Project Title: Caliber's Shooting Range

Re: Caliber's Shooting Range, 4340 Cutler Ave. NE
Request For Permanent C.O.
Engineer's Stamp Dated: 02-05-13 (H17/D089A)
Certification dated: 08-30-13

**RE: CALIBER'S SHOOTING RANGE, 4340 CUTLER AVE. NE
ENGINEER'S STAMP DATED 12-18-2012 (H-17/D089A)**

Re: Caliber's Shooting Range, 4340 Cutler Ave. NE
Engineer's Stamp dated 12-18-2012 (H-17/D089A)

SHEET #
C101

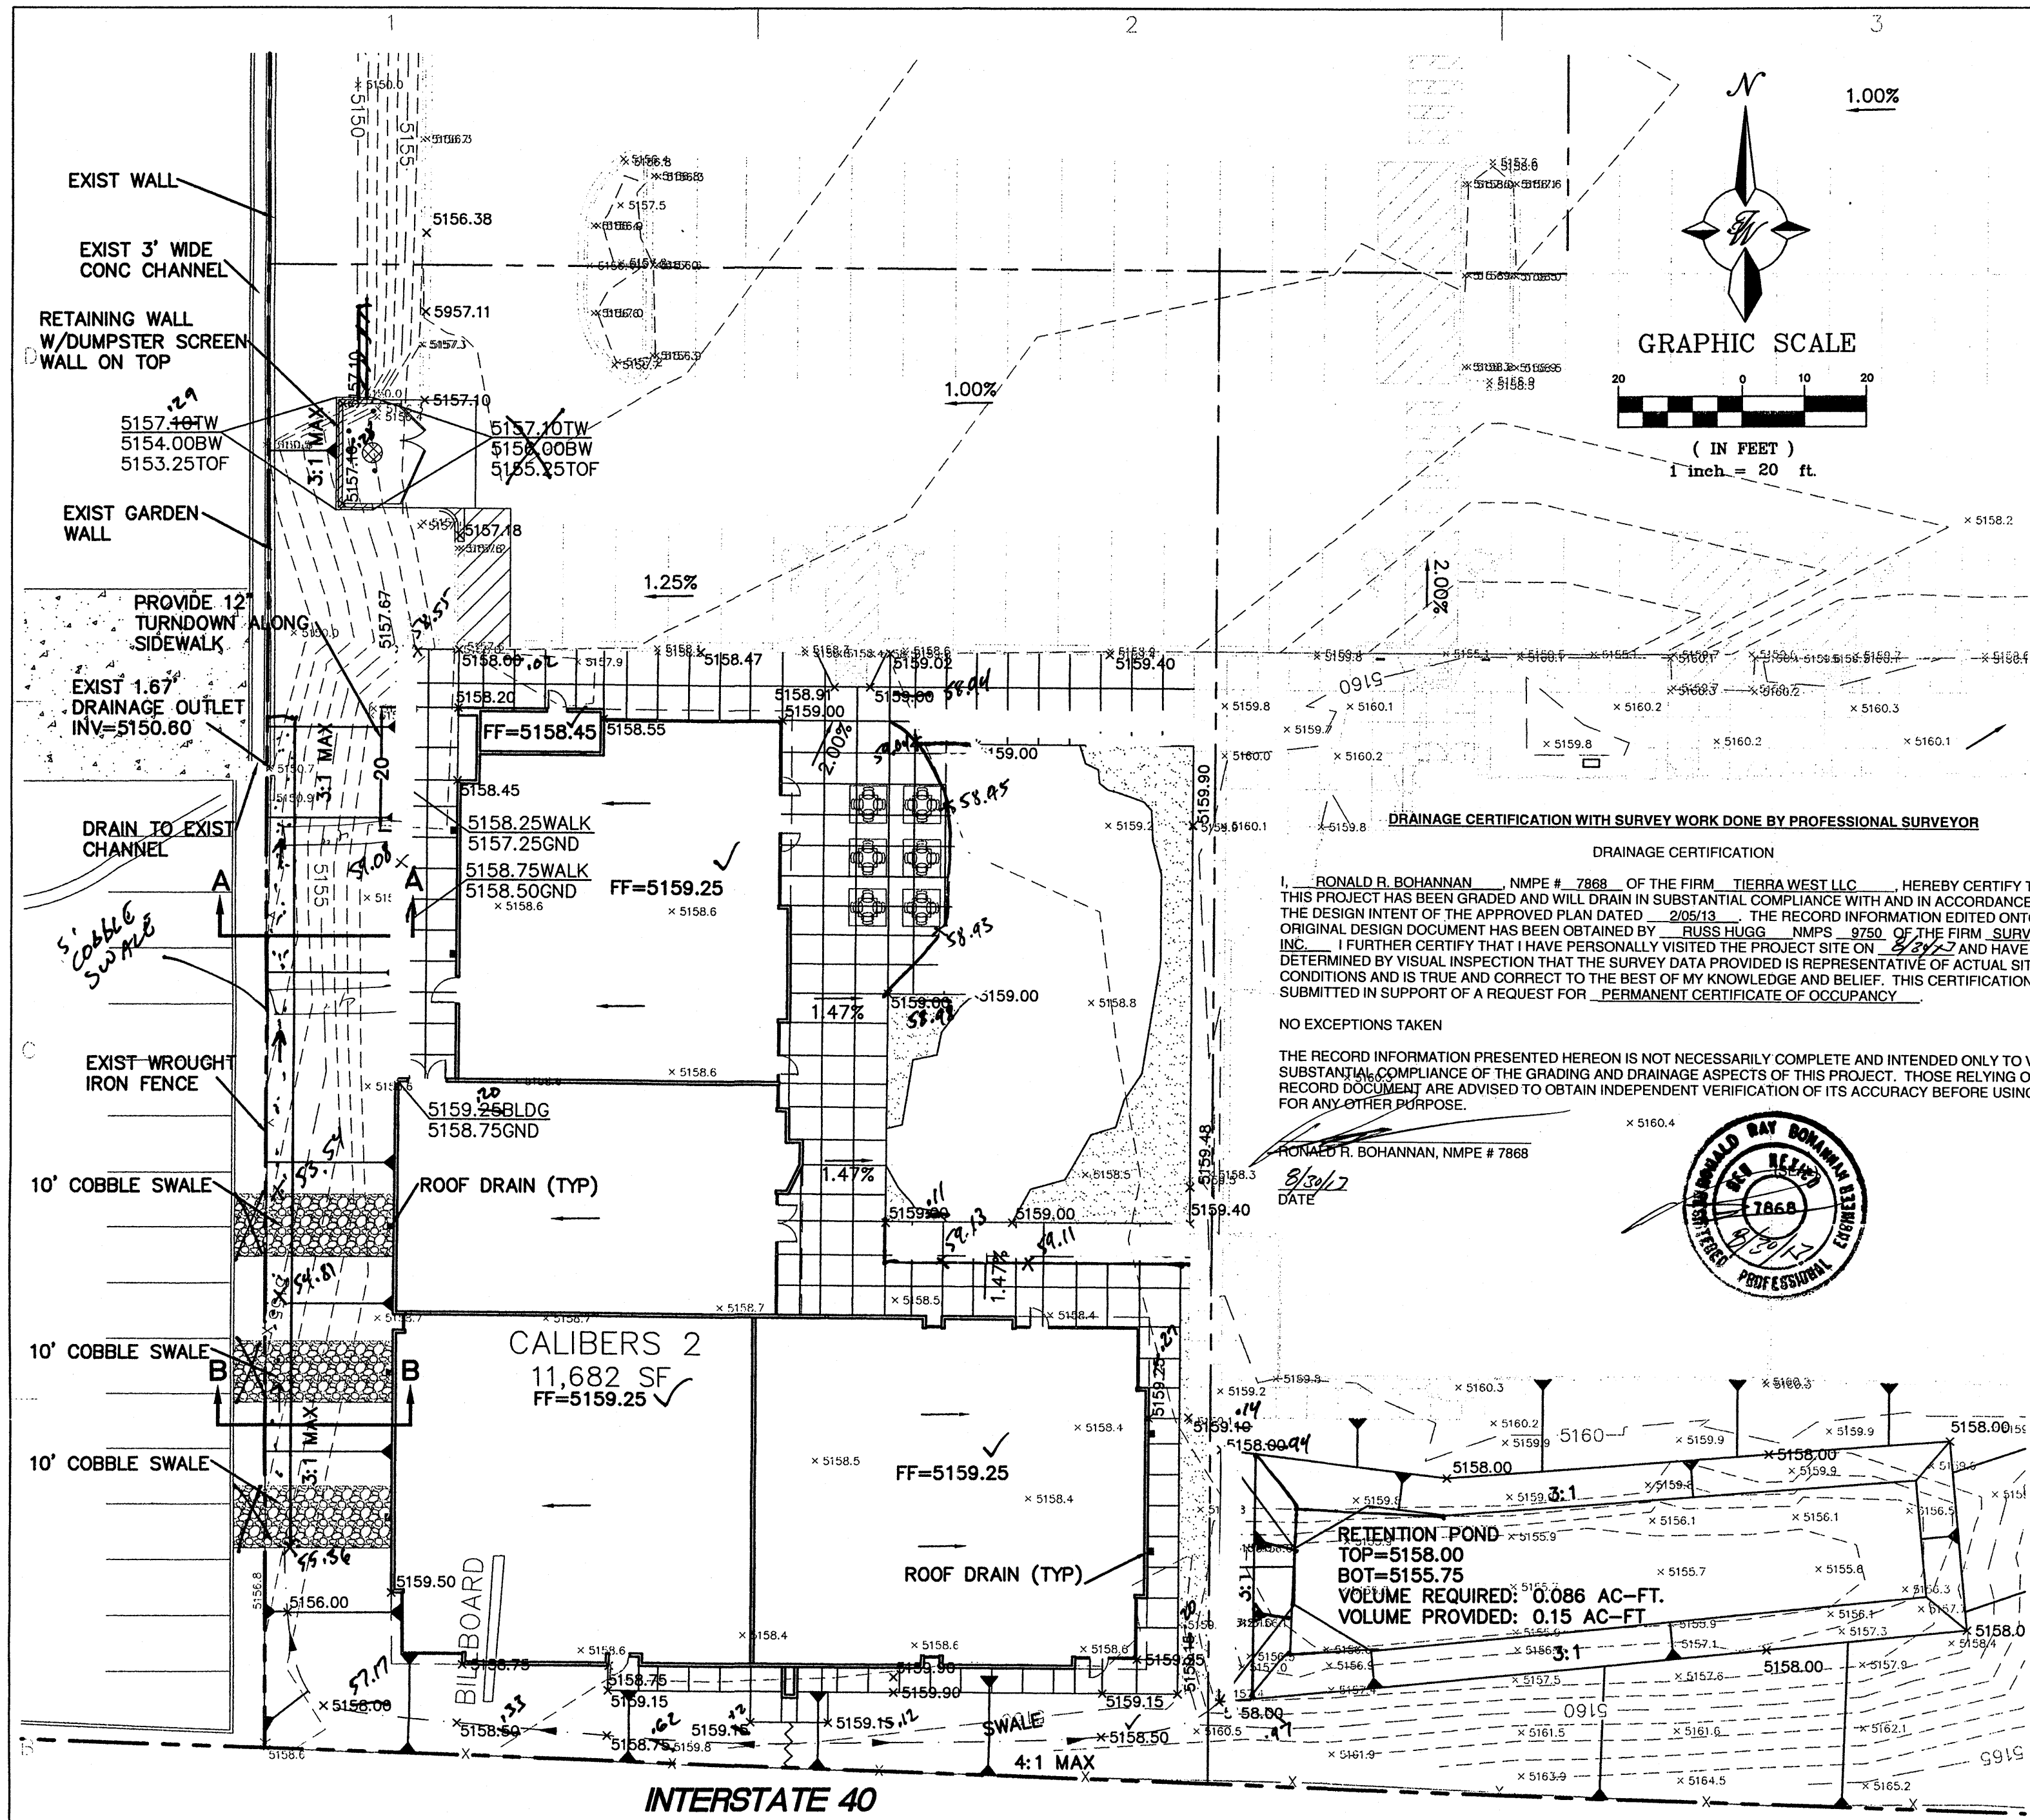
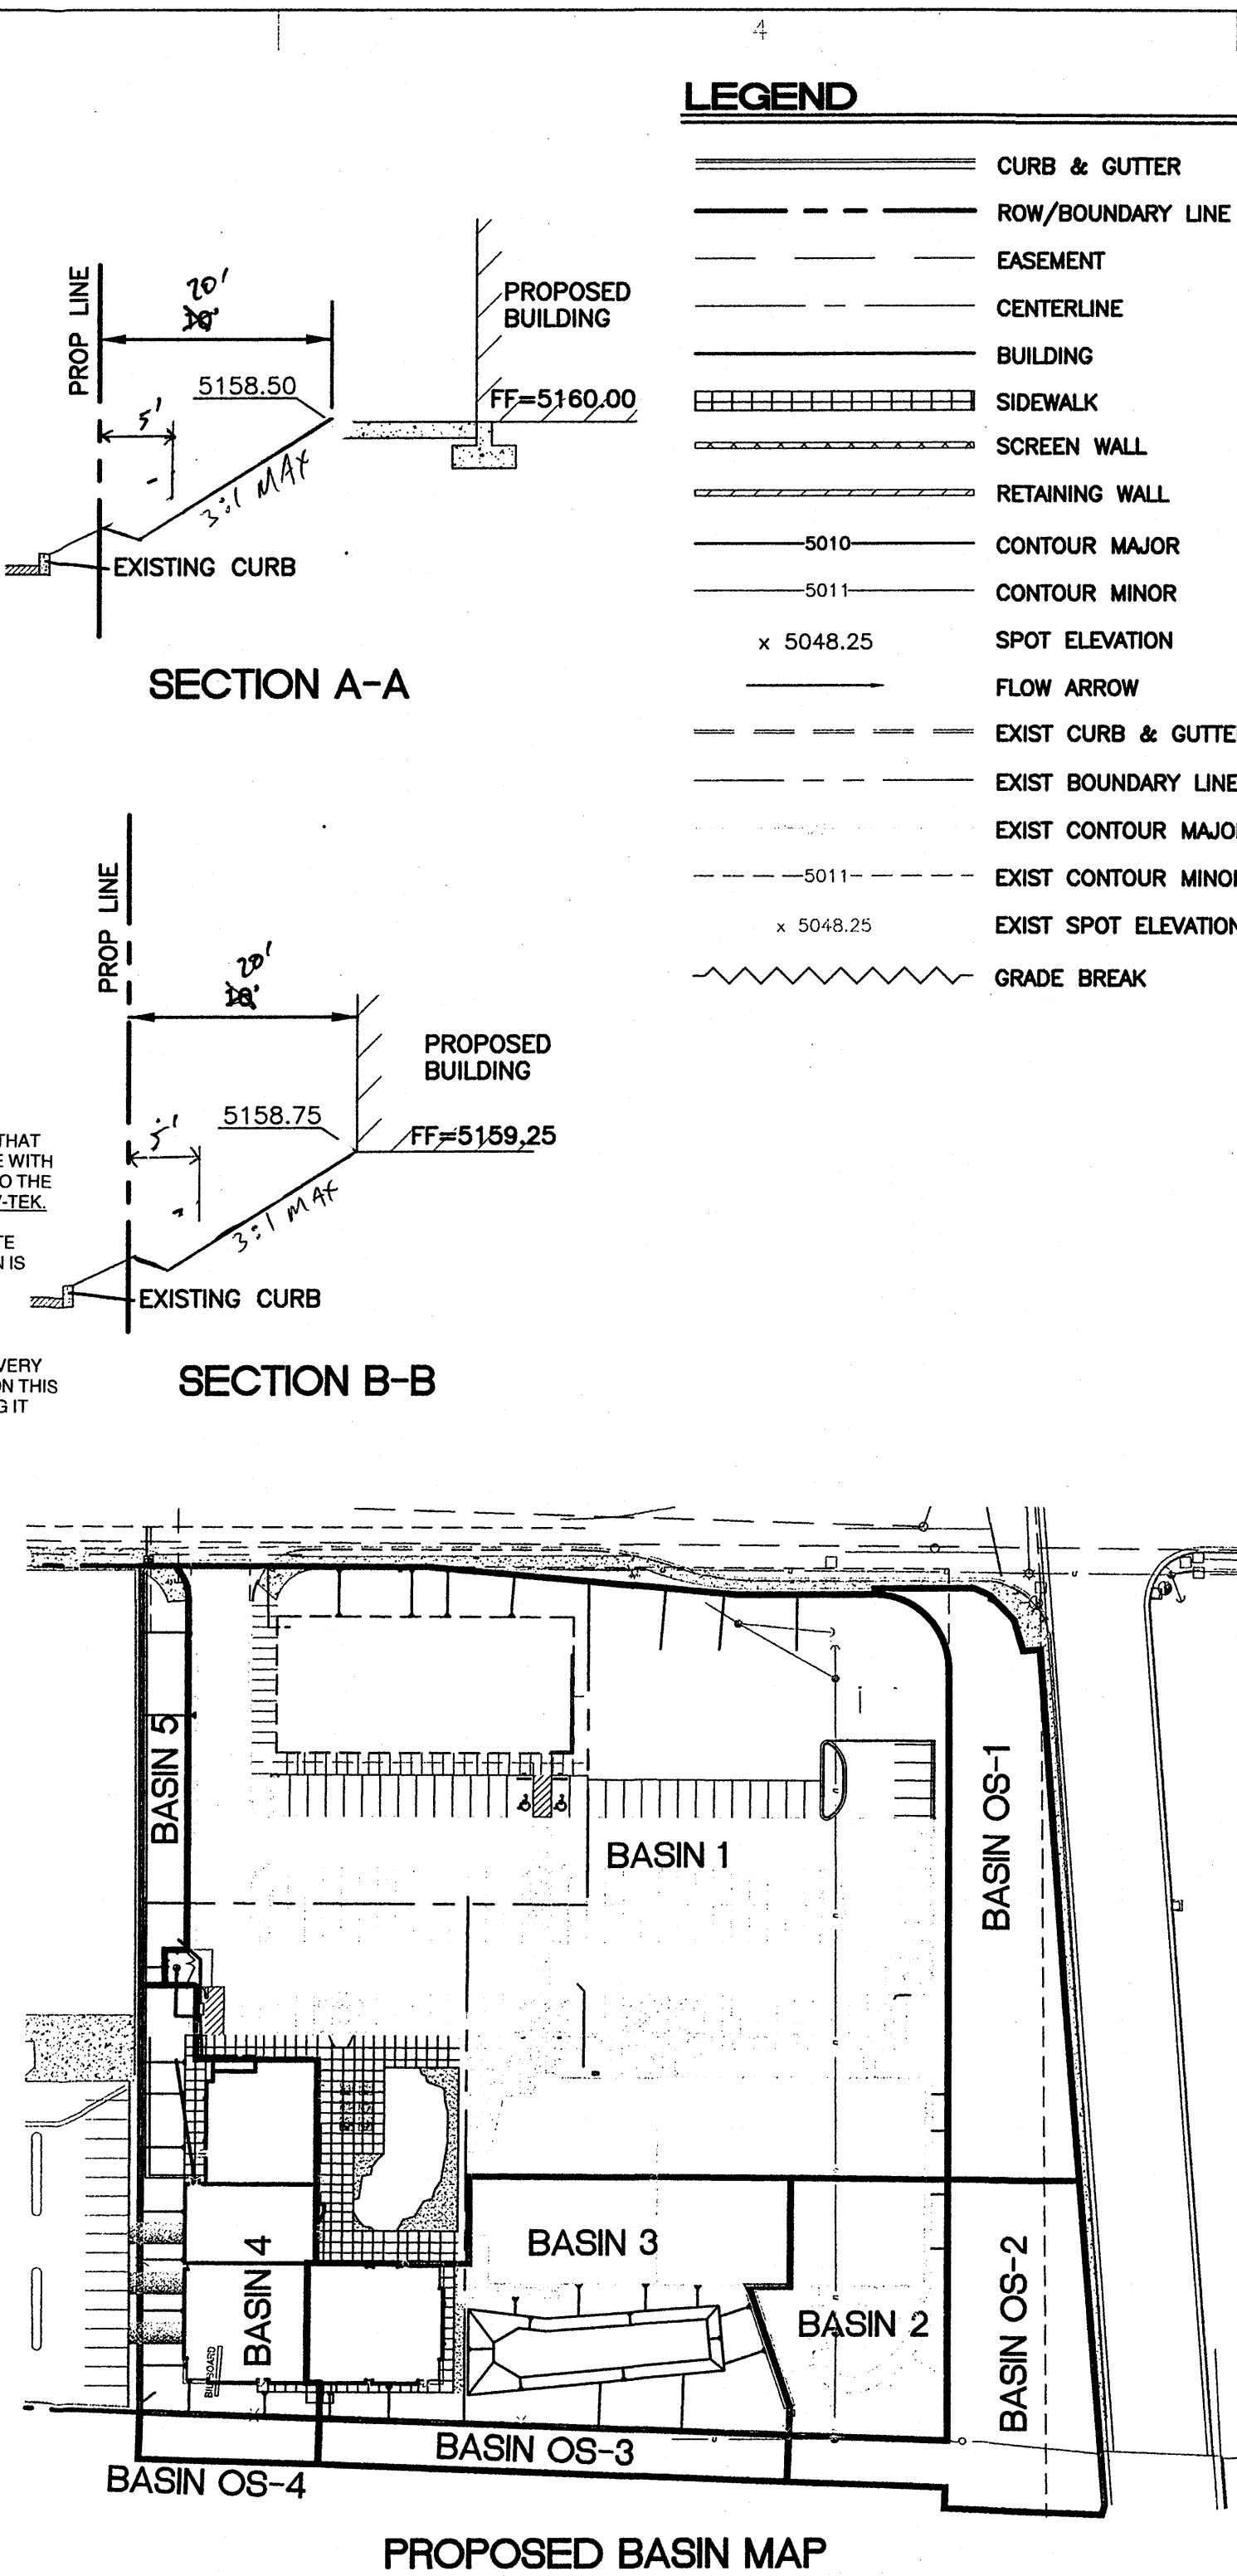
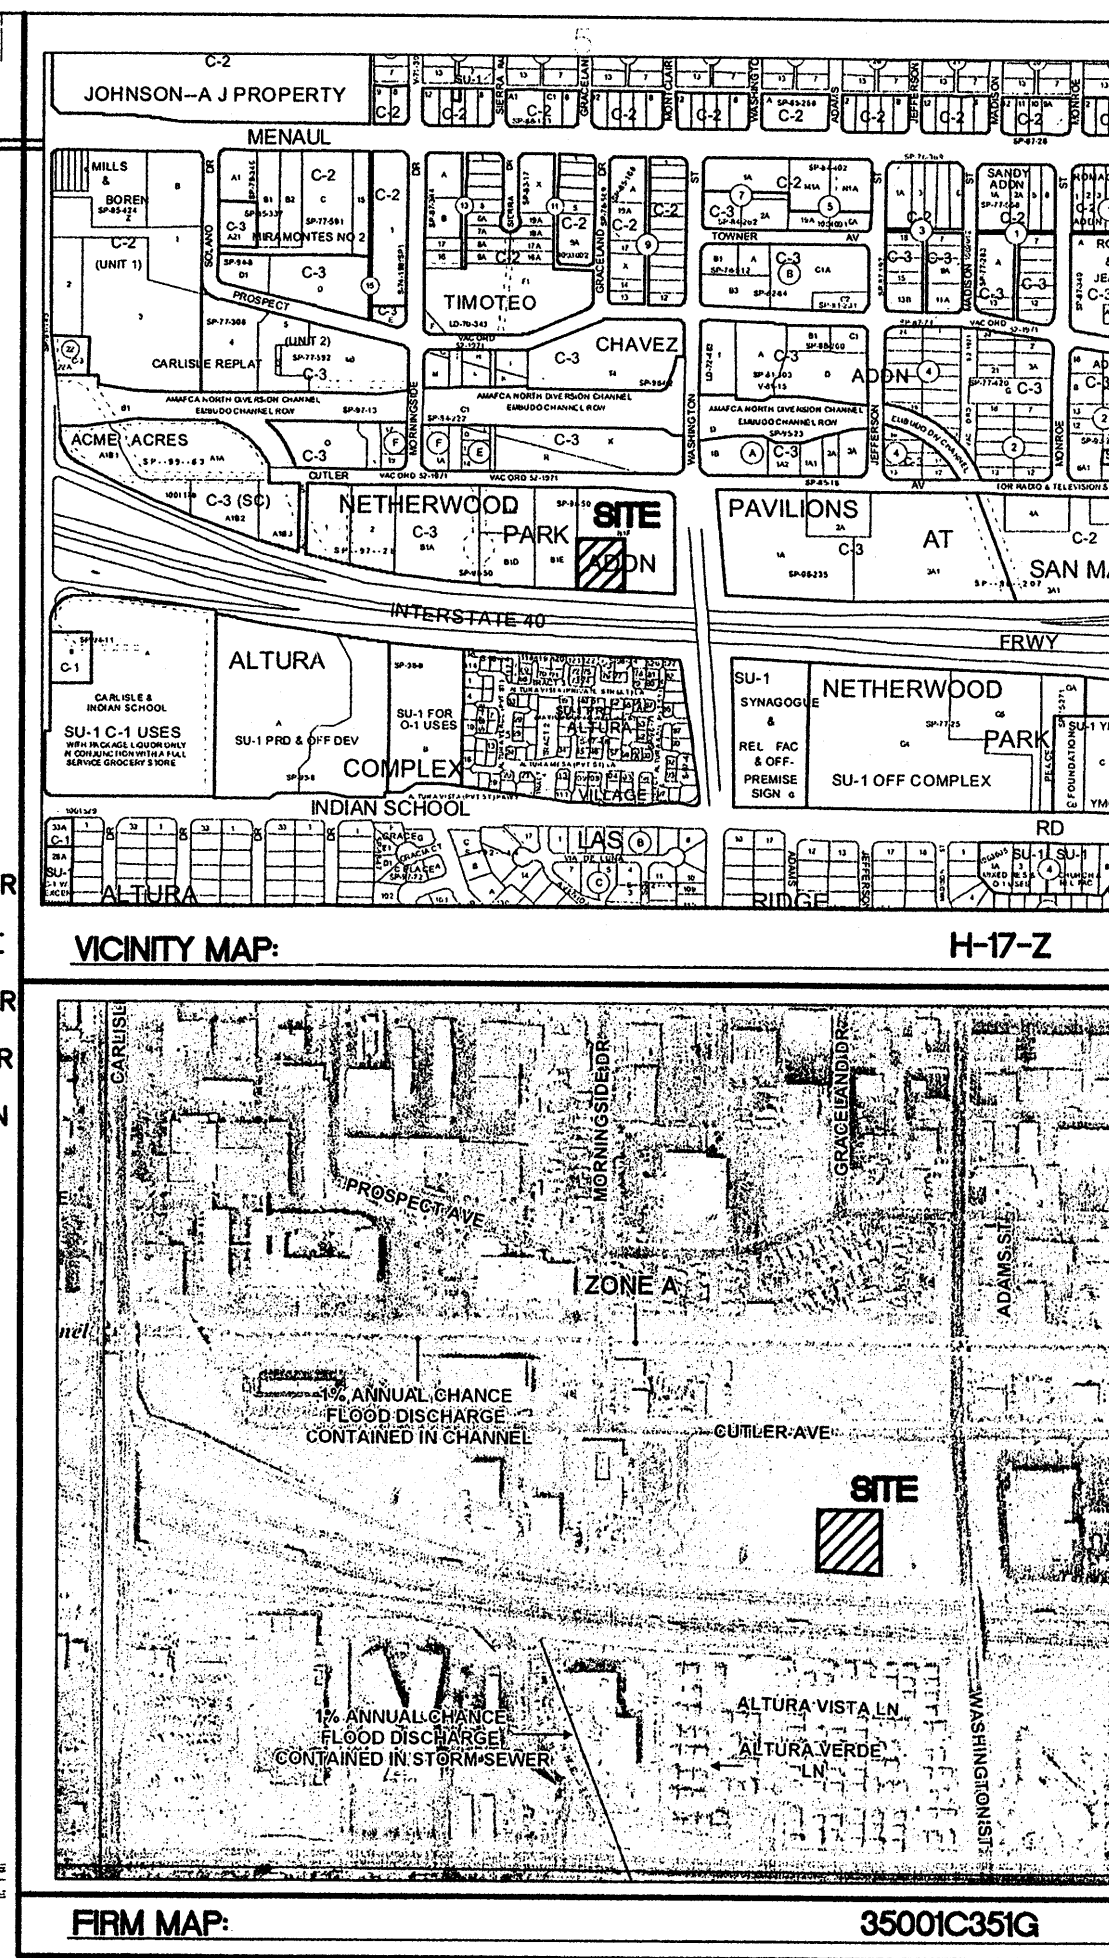
- Add large cobbles, from the discharge point of the two most northerly roof drainage pipes to the bottom of the slope, on the west side of the building.
